Advice on Environmental Impact Statement – Hunter Street Over East Over Station Development – SSD-46246713

Thank you for your correspondence dated 2 December 2022 inviting the City of Sydney (the City) to comment on the Environmental Impact Statement submitted for the Concept State Significant Development Application (SSDA) relating to the Over Station Development (OSD) at Hunter Street East.

The Concept SSDA for Hunter Street East seeks consent for a building envelope above the Hunter Street Station eastern site located at 44-48 Hunter Street, Sydney, including:

## Hunter Street East

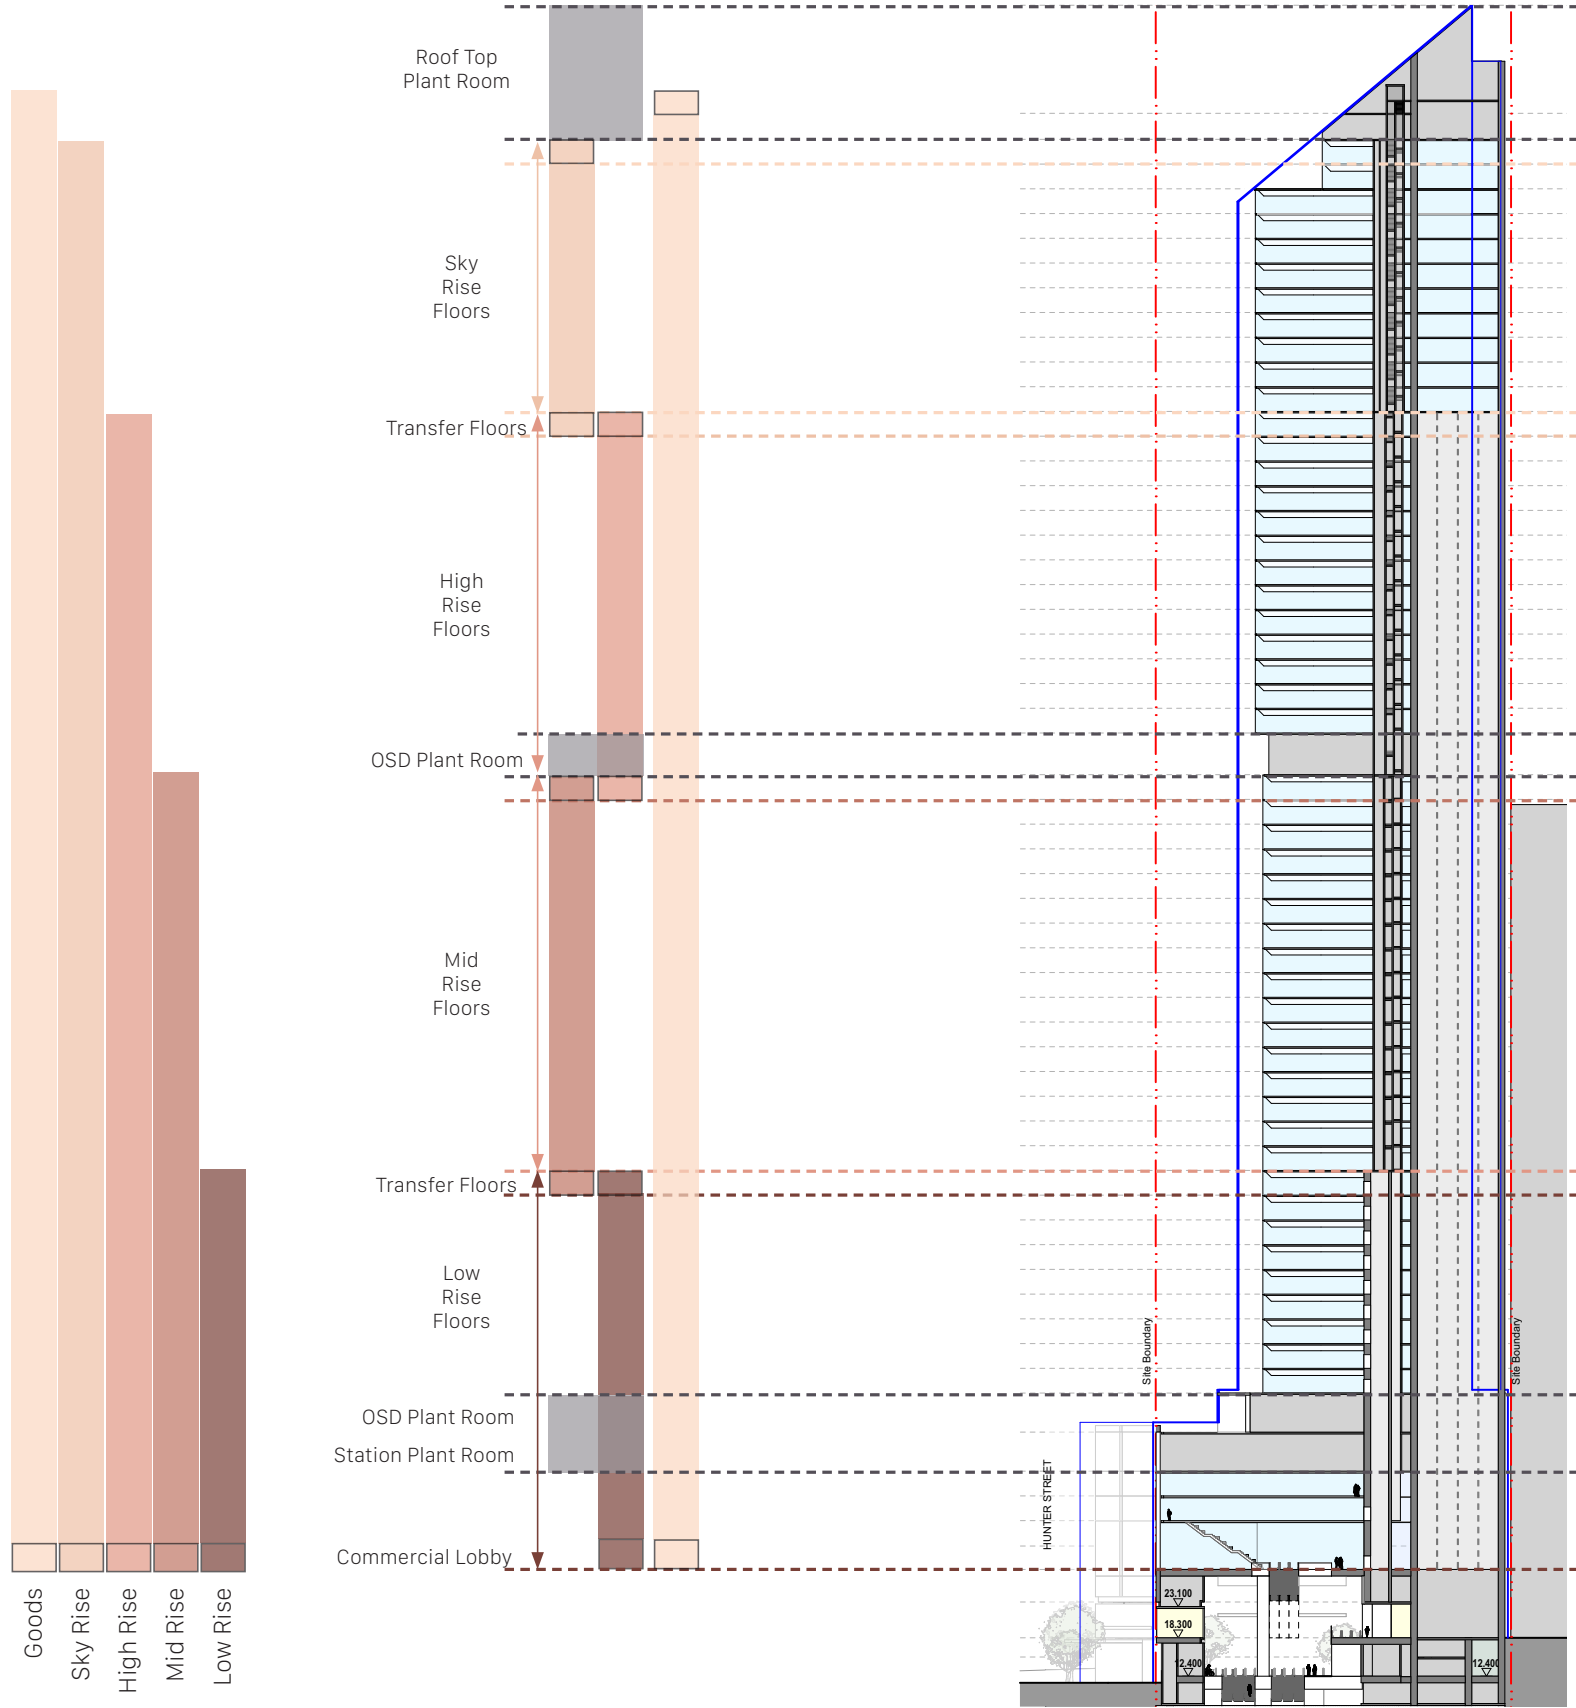
- There are only three escalators servicing access to the commercial lift lobby located on Level 1 which is approximately three levels above O'Connell Street. These escalators are servicing 25 passenger lifts. It is queried whether this is sufficient.

## 92. Combined Ground Floor Plan

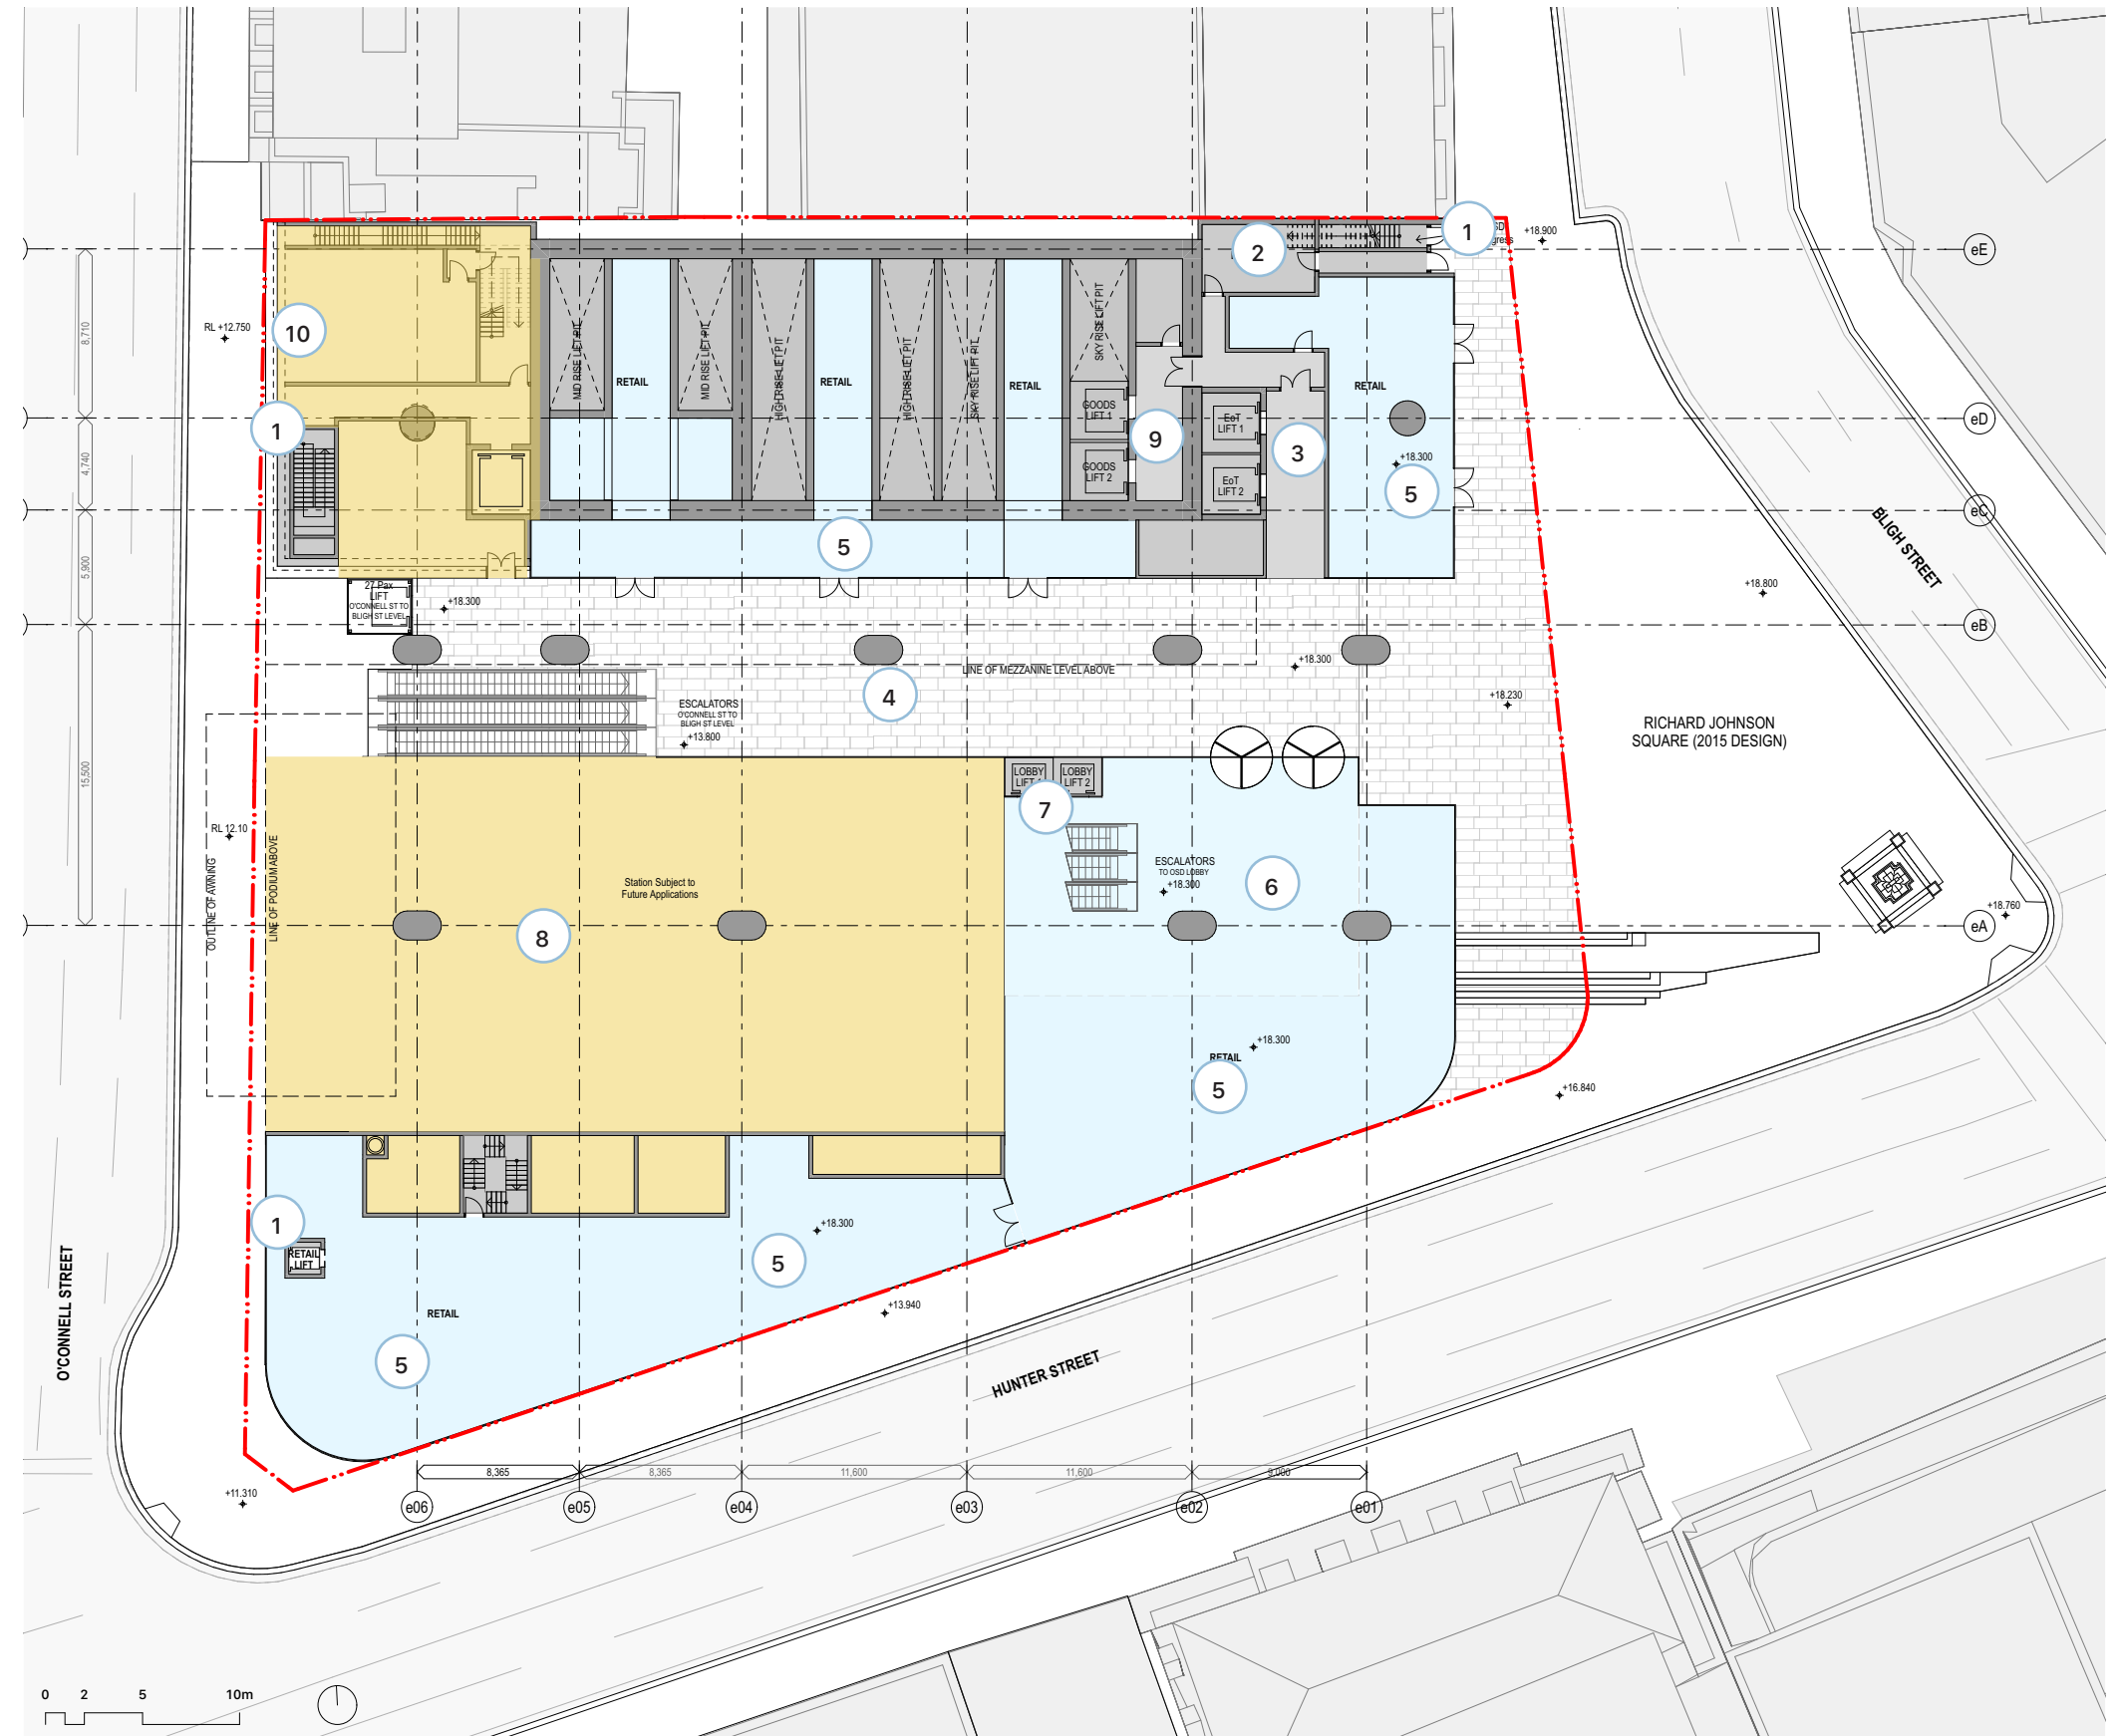
The reference design shows a two-way driveway across the O'Connell Street footpath, with very wide splayed kerbs. Any driveway should be perpendicular to the kerb to minimise impact on the pedestrian footpath. The proposal should also reflect the opportunity to close O'Connell Street at Hunter Street, as shown in the draft City North Public Domain Plan.

- There is no line of defence shown at either O'Connell or Bligh Streets entries to the Metro. Protection bollards need to be allowed for within the site and should not appear in the public domain.

**GA Floor Plans**  
East - Level 3 - EOT

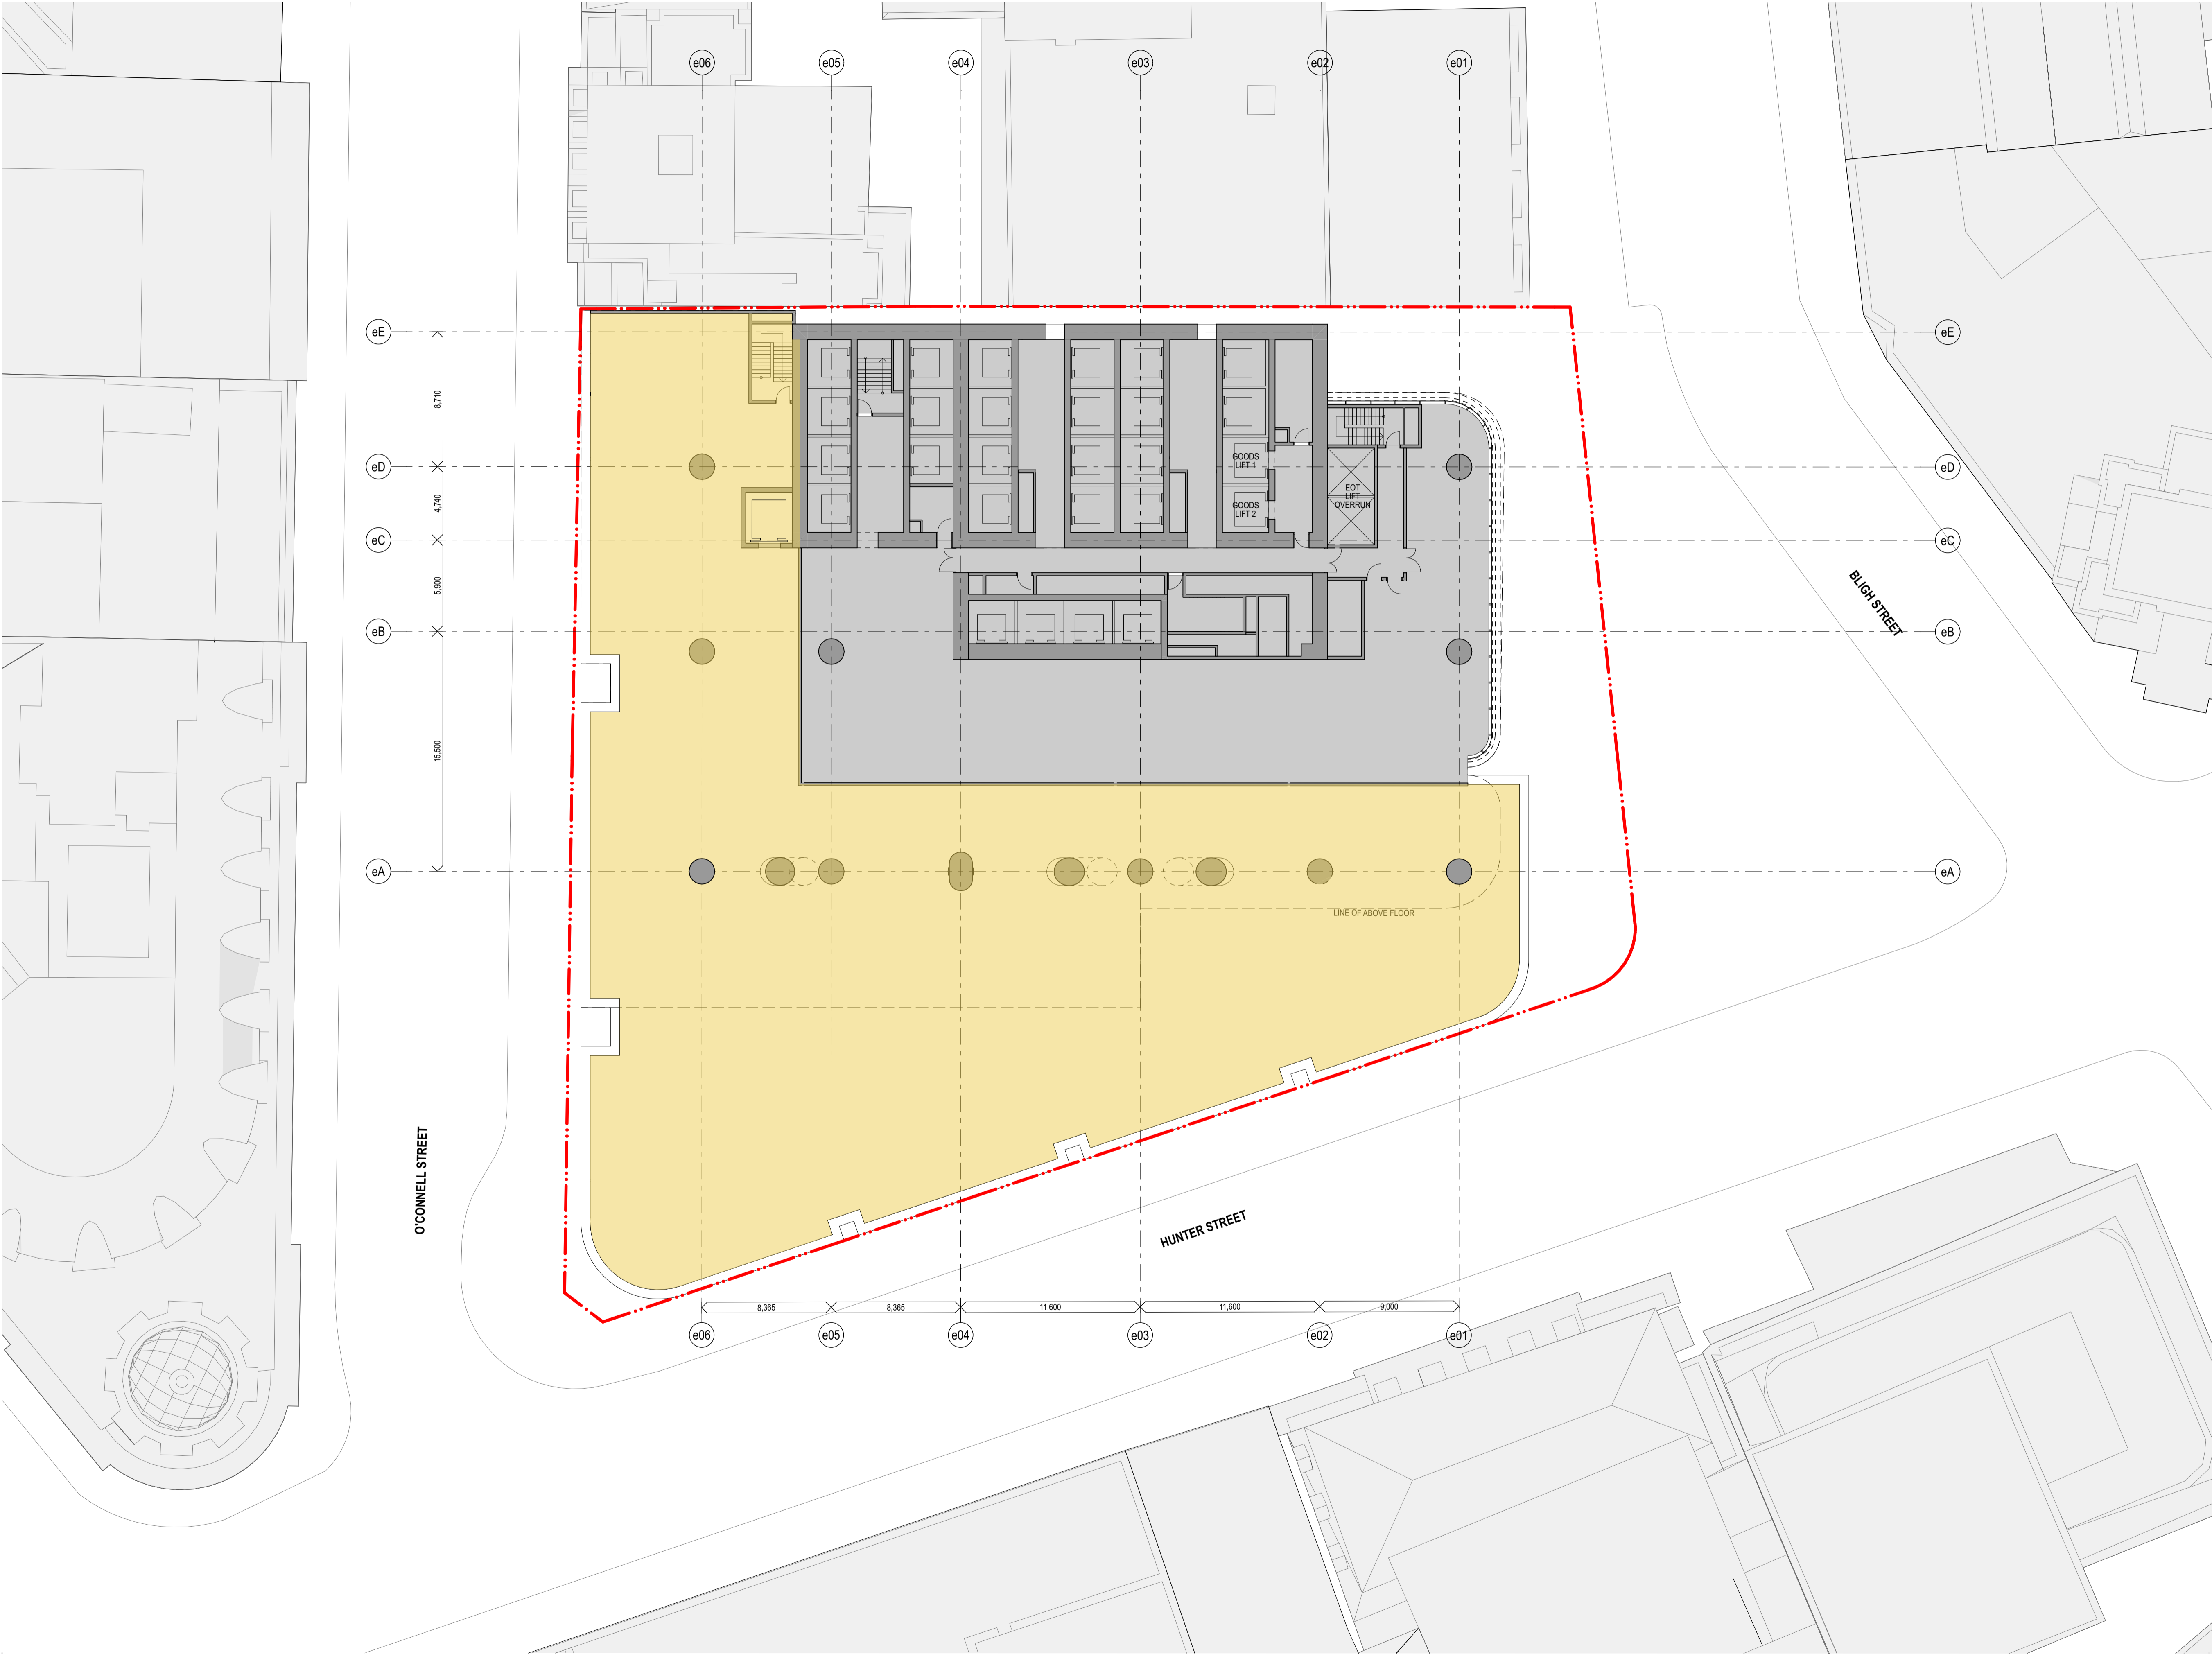
- The end of trip facilities are located on Level 3. There are only two lifts servicing the end of trip area. There is no access provided to the lift cores and cyclists will need to use the EoT lifts to travel to the L1 commercial lobby to get to their office levels. This is not convenient.
